CGS comments, April 19, 2023

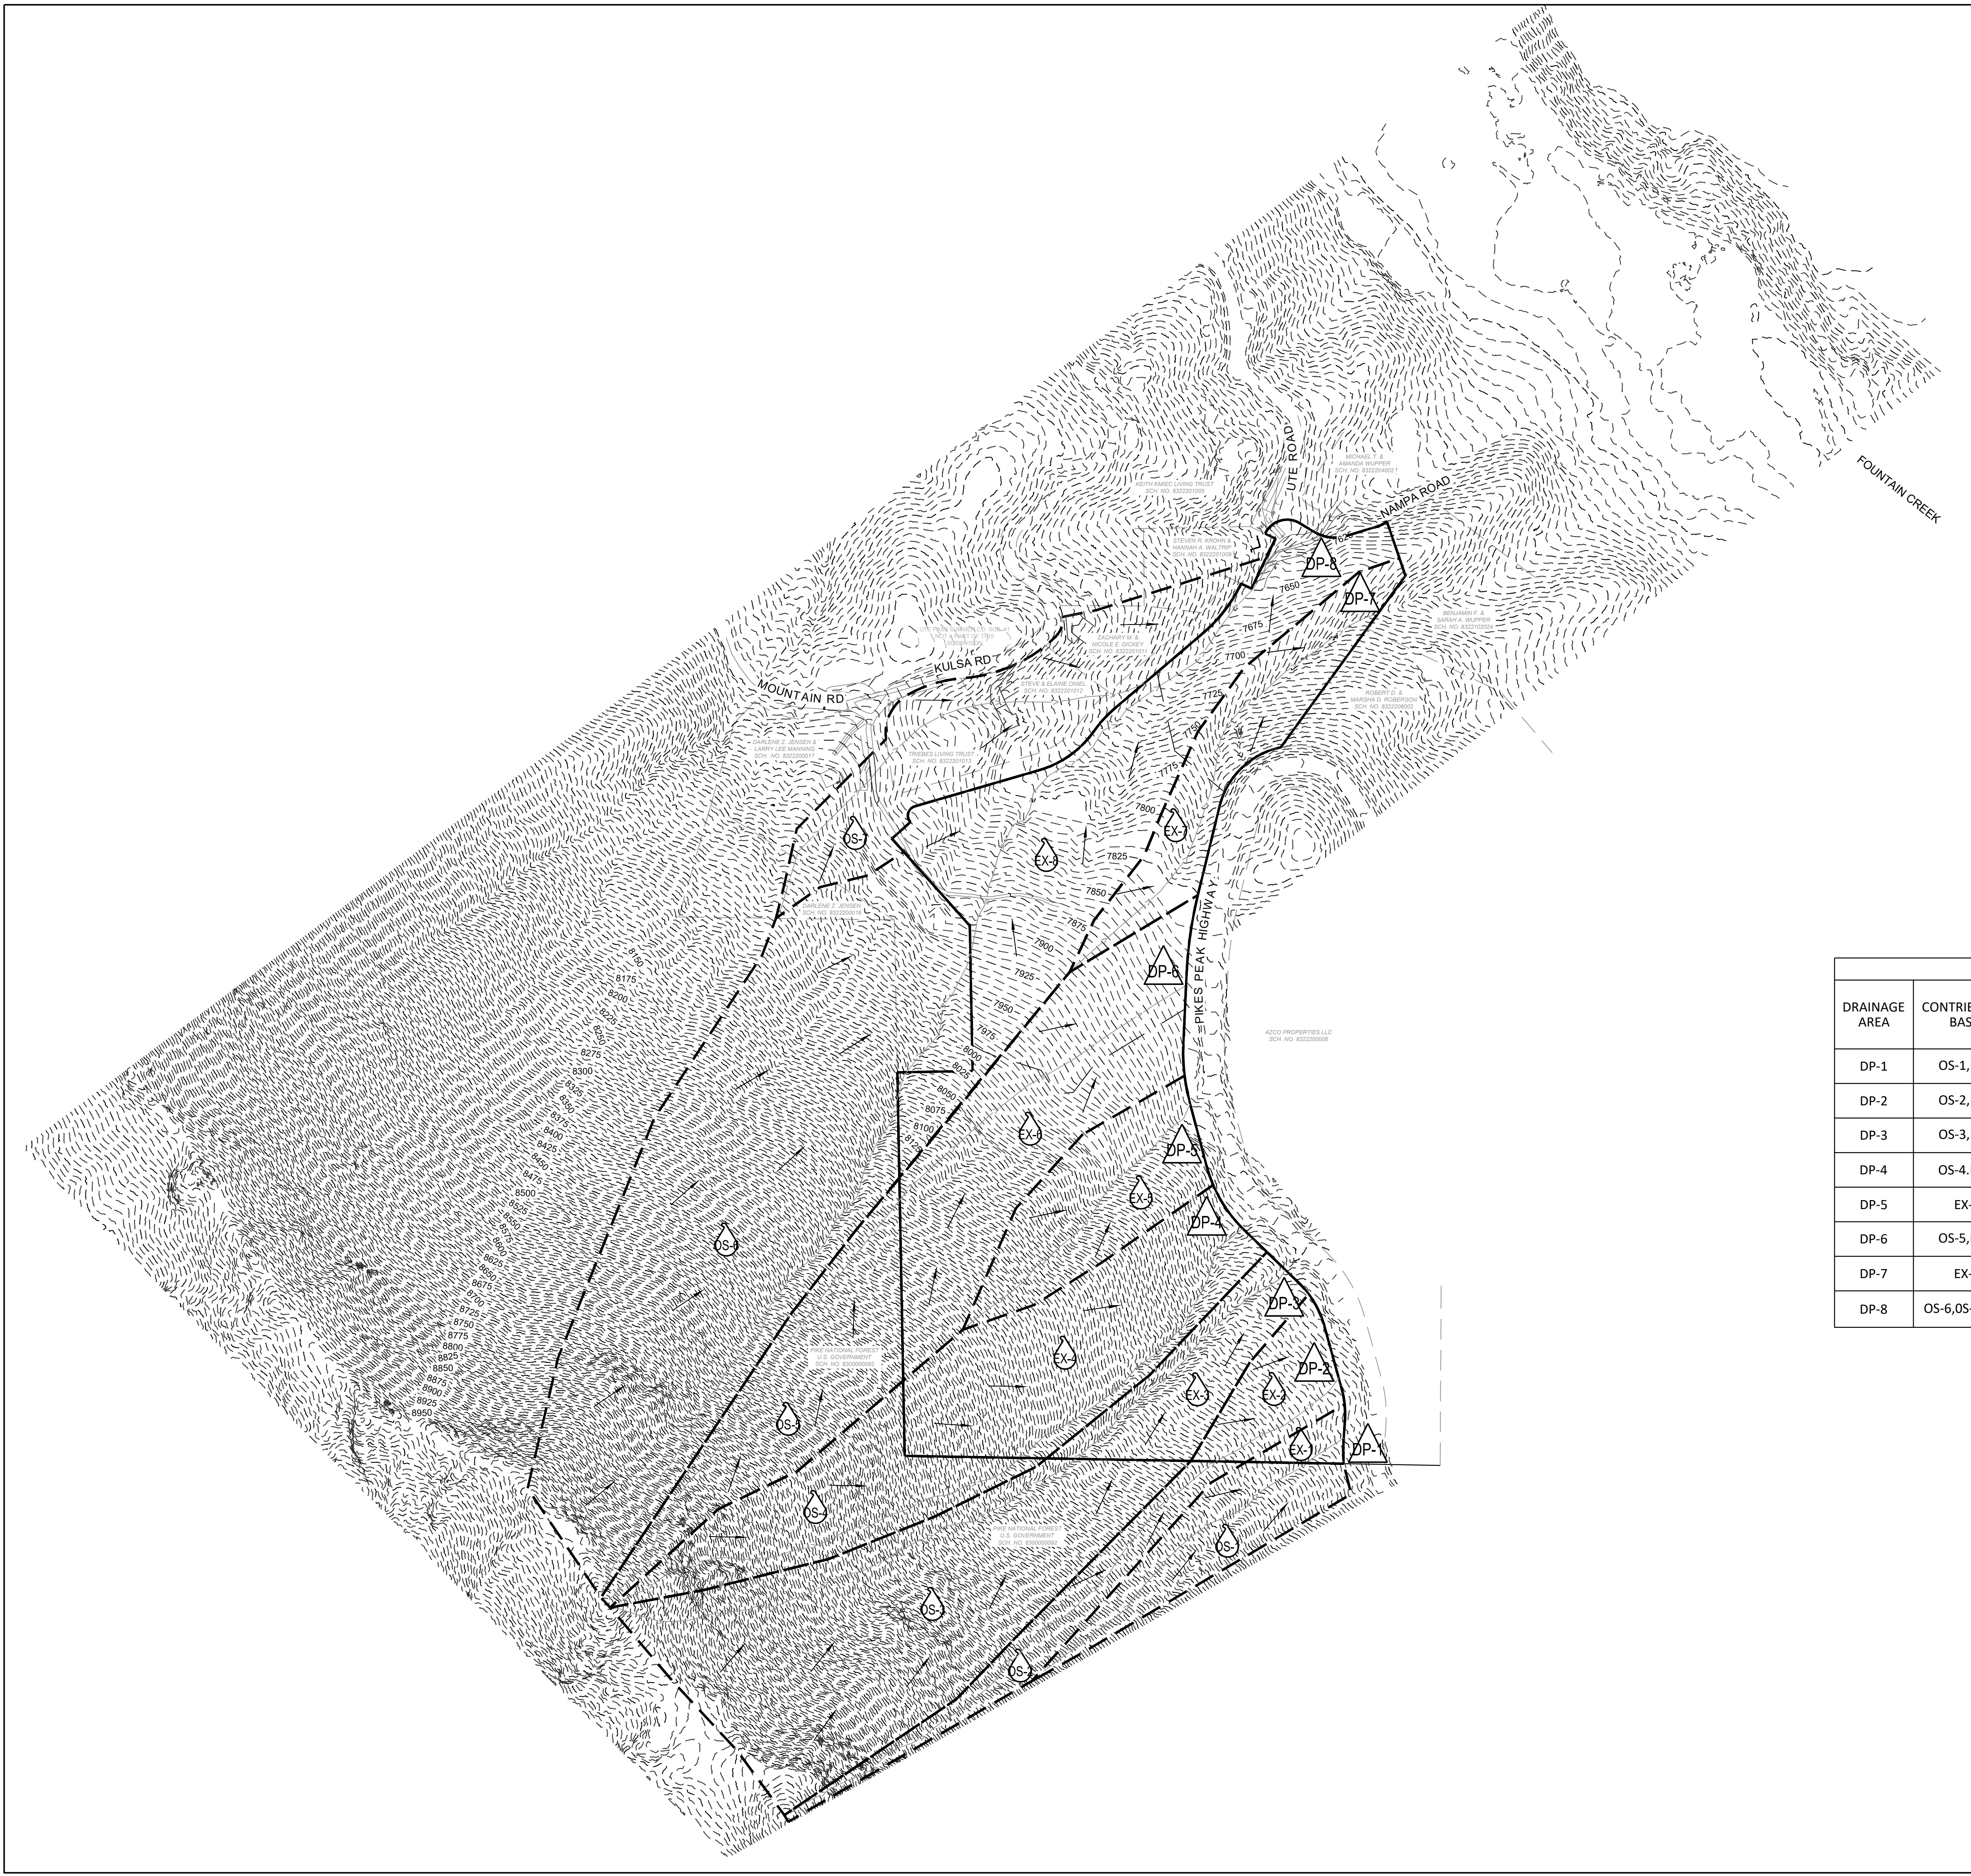
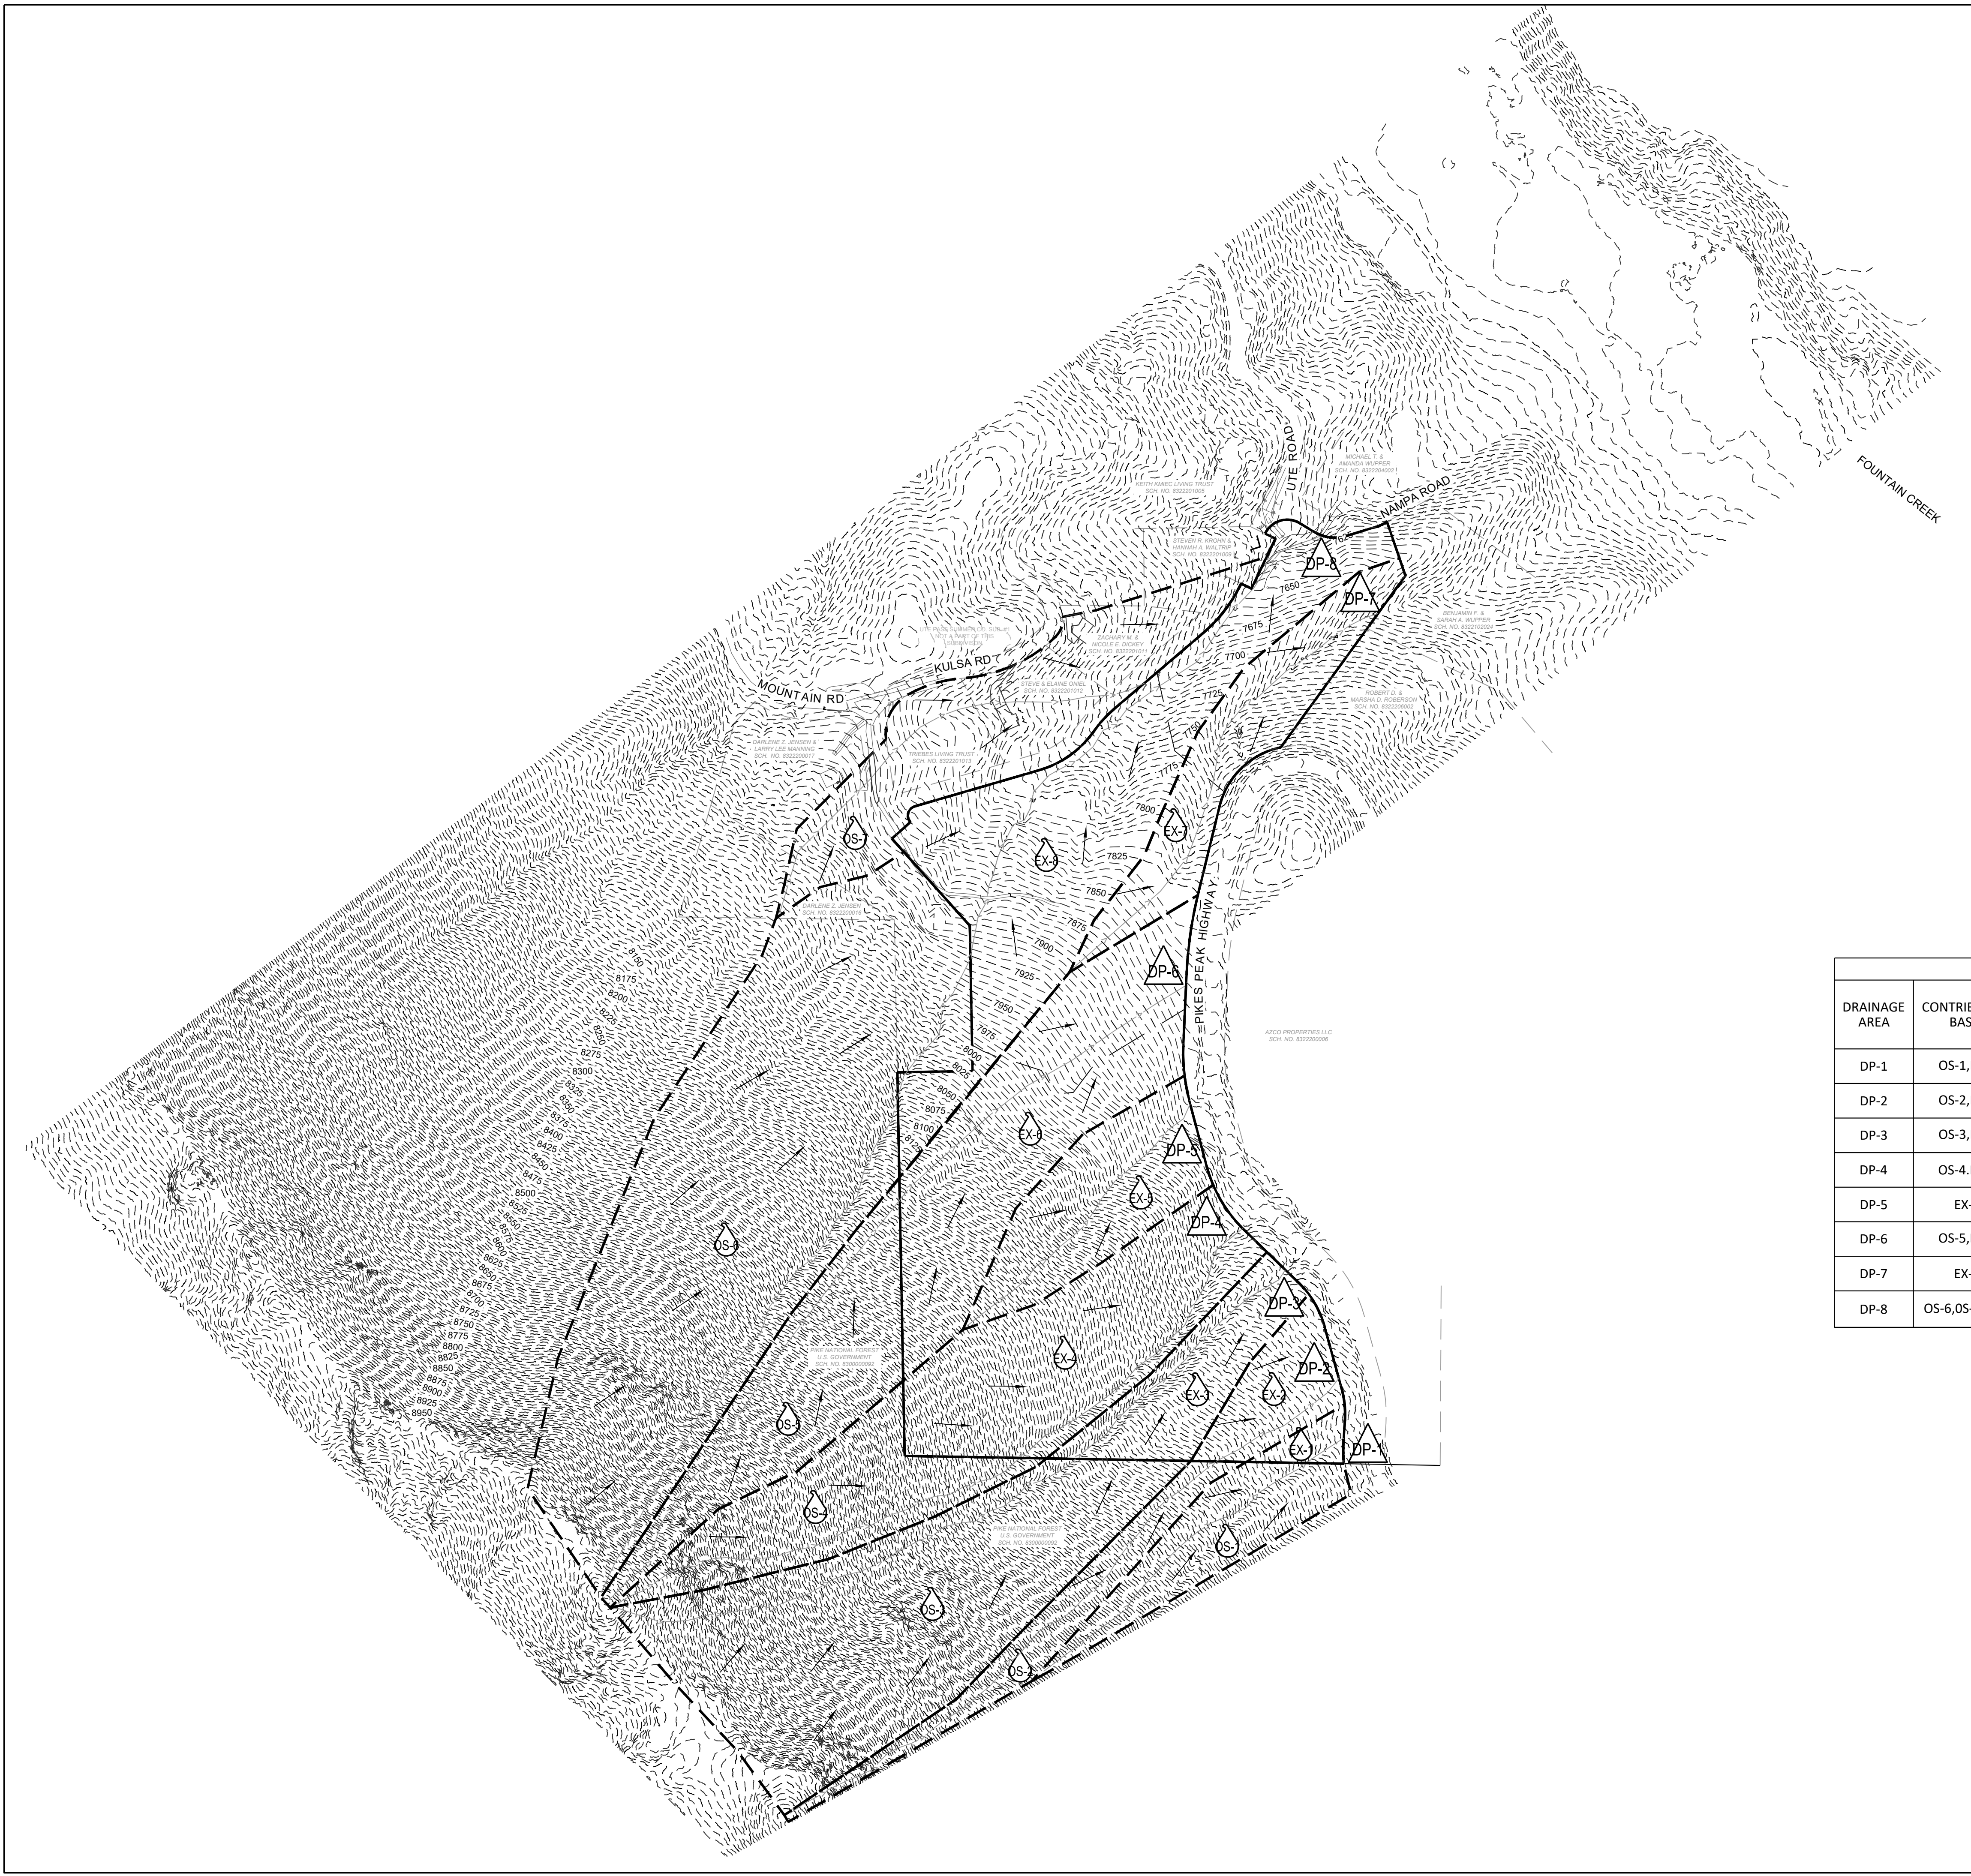
CGS recommends that the submittal not be approved until our comments about the debris flow hazard at this location are addressed. The submitted documents have not evaluated the debris flow hazard at this location. RMG’s report (Soil and Geology Study, 3.18.22) states, p.10, “*The gradients and source materials on the subject property site are, in general, not conducive for generation of debris flows.*” However, the gradients and source materials in the drainages that impact the site are conducive to the generation of debris flows or hyperconcentrated flows. We discussed this in our previous comments on August 5, 2022. The calculated flows for OS2, and 3, as shown on the drainage plan, do not indicate they are bulked for debris flows and appear to be only for clear water flow. These flows should be bulked with sediment, and the resultant onsite flow should have mitigation designed for it. It should be pointed out that wildfire will increase the likelihood of debris flows at this location.

The Colorado Geological Survey (CGS) agrees with the applicants’ consultant that the proposed lots do not contain geologic conditions that would preclude the proposed residential use and density. However, a hazard within the site from potential debris flow/hyperconcentrated (high sediment yield) flow and potential for highly erosive flow require evaluation and mitigation. RMG’s report (Soil and Geology Study, 3.18.22) states, p.10, “*The gradients and source materials on the subject property site are, in general, not conducive for generation of debris flows.*” CGS visited the site (38.9087, -104.9847) on August 3, 2022, and noted that a hyperconcentrated flood and debris flow hazard exists for at least drainage OS2 (as labeled in the Preliminary Drainage Report by SMH dated 7.22). This hazard can be observed in the source area for OS2, which includes steep slopes and material available for transport, including fallen trees, boulders, and weathered granite (grus). The drainage report has calculated flows of 5.10 and 28.55 cfs for the five and 100-year storm events, respectively, in OS2. CGS recommends that these flows be bulked for high sediment and debris flow yields, as indicated in the following table of values. This table is a generalized but well-understood industry estimate of bulking factors for these types of flows.

This table indicates the calculated storm events expected at this location should be bulked by 1.25 to 1.67 to predict their volume. Flows can be highly erosive and contain sediment, boulders, and trees. It should be noted that calculated flows for the five and 100-year events are greater for OS3 than for OS2 (13.74 and 76.89 cfs, respectively), with potential impacts on the existing building on the Manning Property.

Excavations (test pits) can help evaluate if flows onto the sites have historically been primarily hyperconcentrated or have included debris flows. The flows can also be age dated by carbon materials to help determine recurrence intervals. Based on the volume of flow estimated, CGS recommends setback distances from the flow channel for building locations be determined and shown on the plans. We also recommend that the area of flows is depicted on the site plans and that the conveyance of the flows is evaluated, and the applicants' engineers discuss protection from deposition and erosion to the planned roadway and homesite locations.
